Our Ref: EN010093

Application by Cory Riverside Energy for an Order Granting Development Consent for the Riverside Energy Park

Advice following issue of decision to accept the application for examination

1:24,000 @ A3	Electrical Connection Refined Application Boundary
16/05/19	
Drawn: HG	
Checked: RG

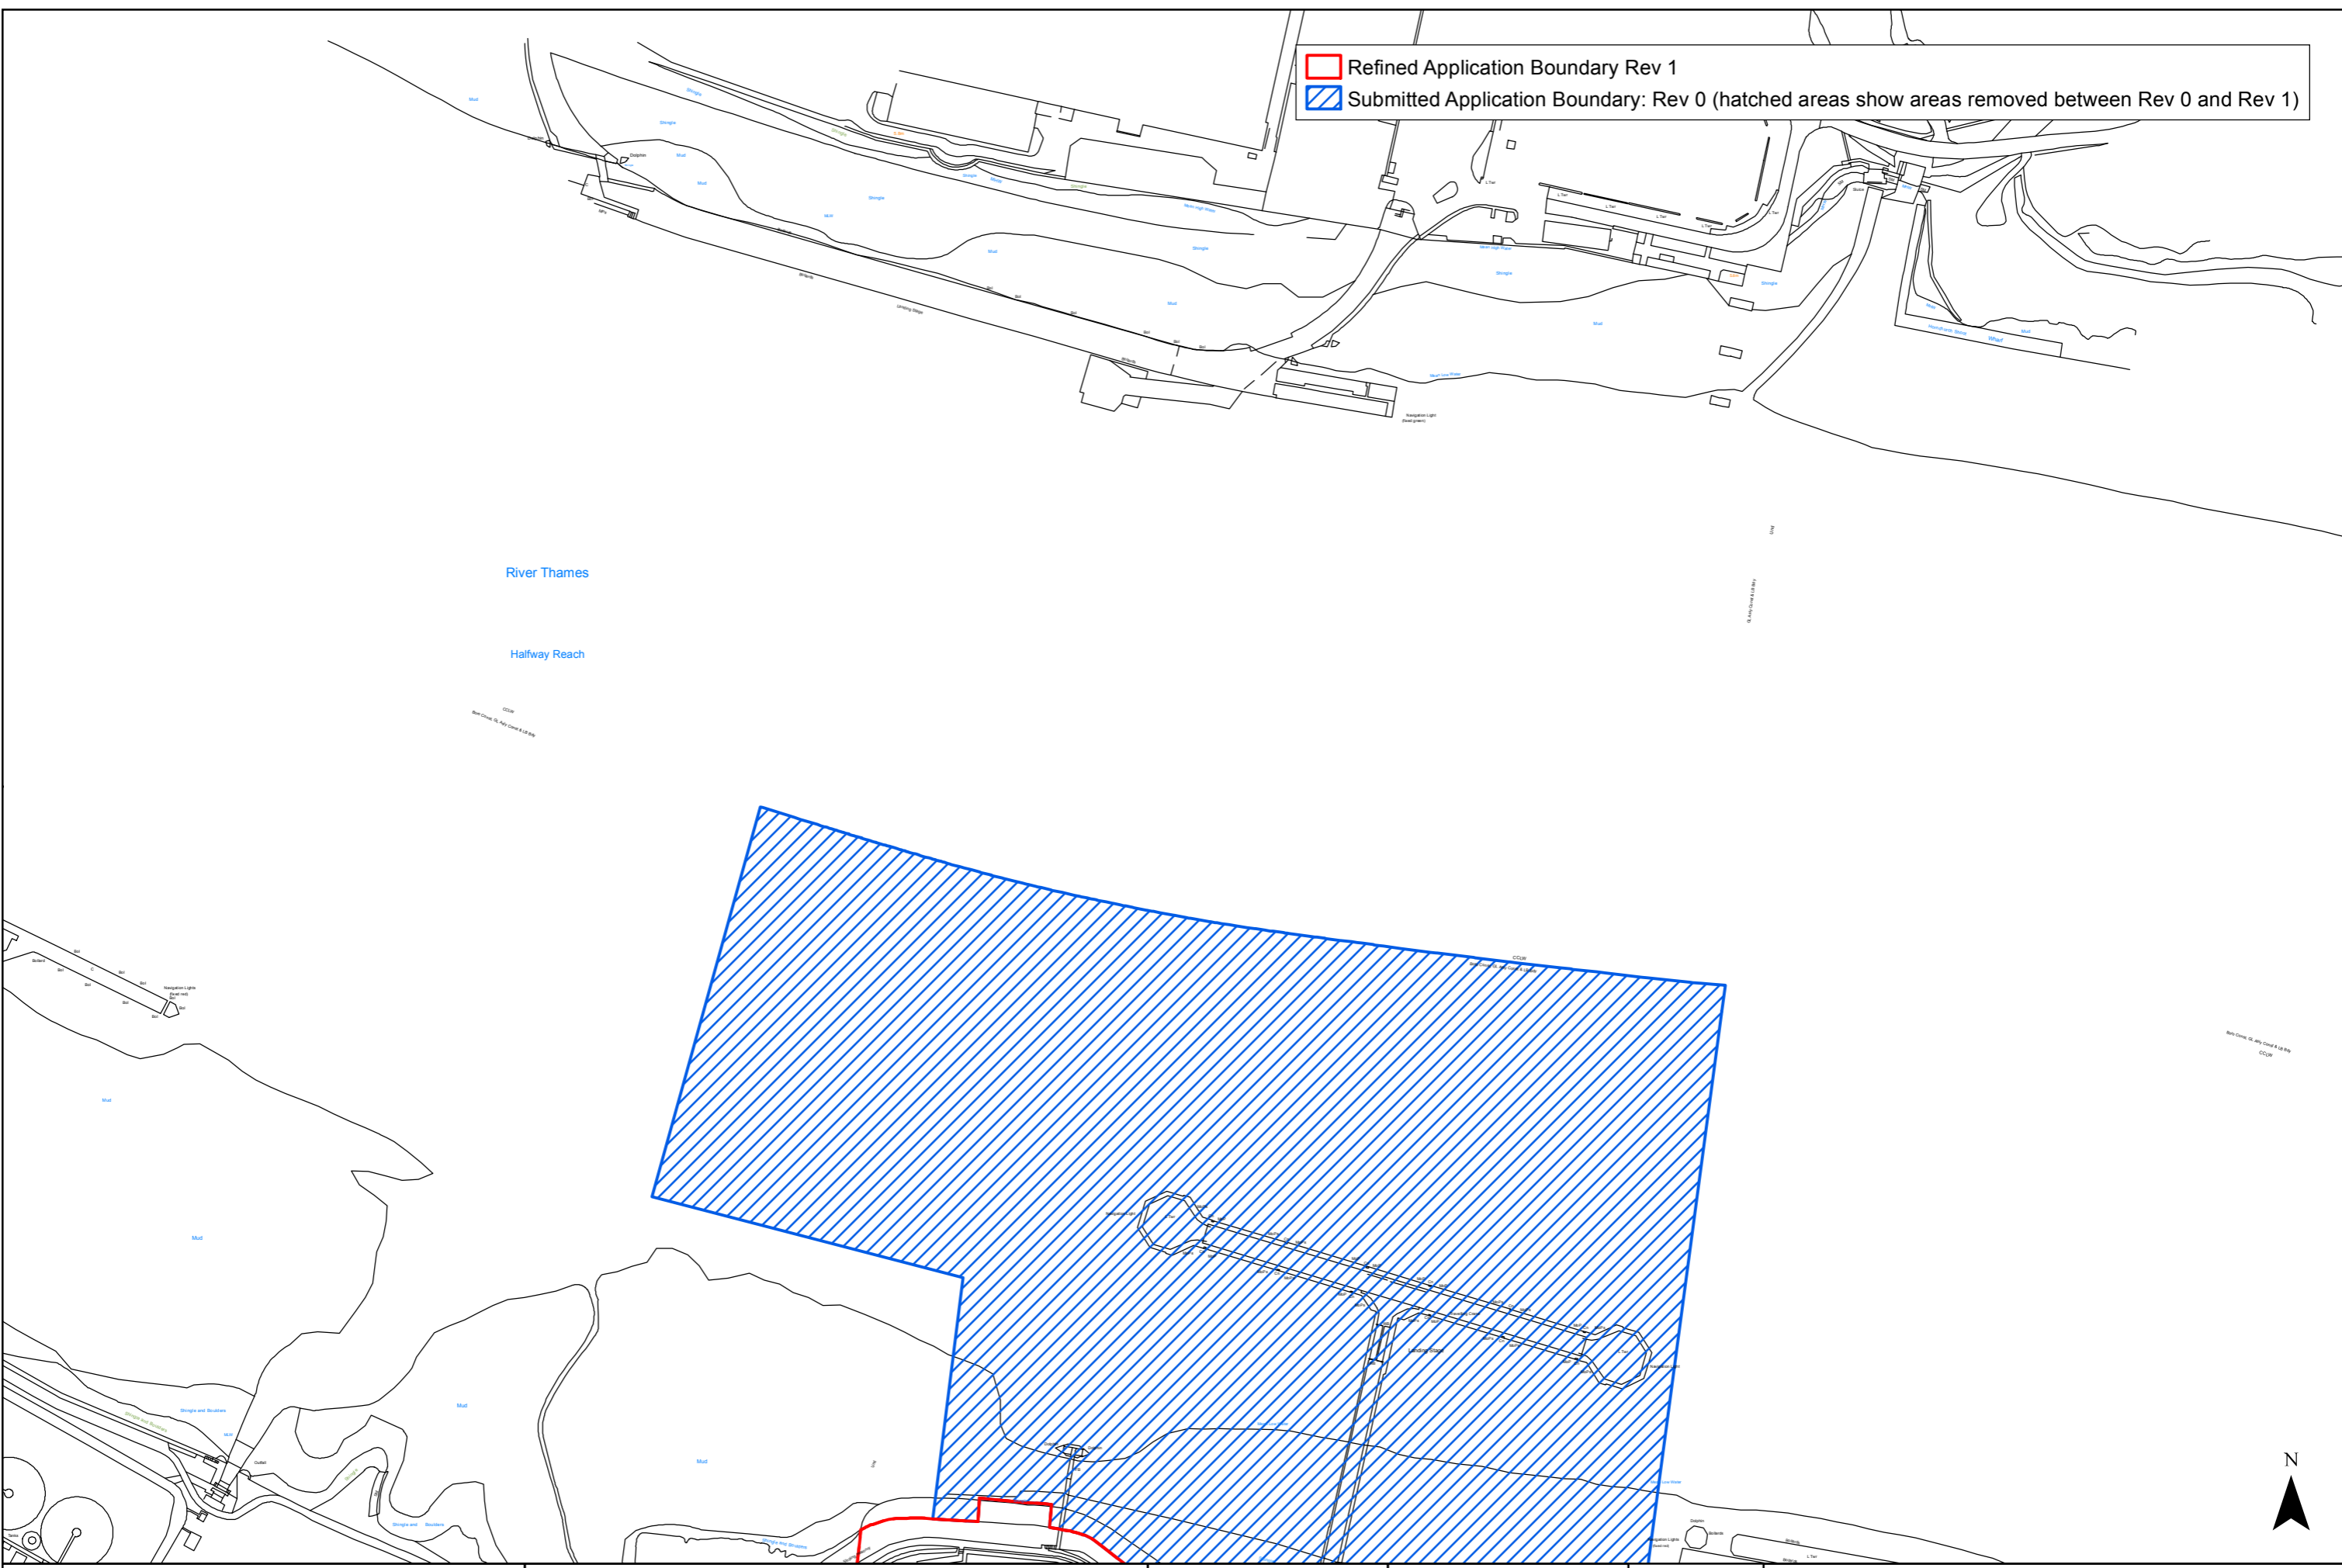
The application contains two alternative routes for the cable connection, which makes for a wide range of proposed Compulsory Acquisition rights. As noted in paragraph 3.2.10 in Chapter 3 of the Environmental Statement a decision will be made with the UK Power Networks. The ExA when appointed is likely to request the Applicant to reach a conclusion regarding the choice of route as early as possible.
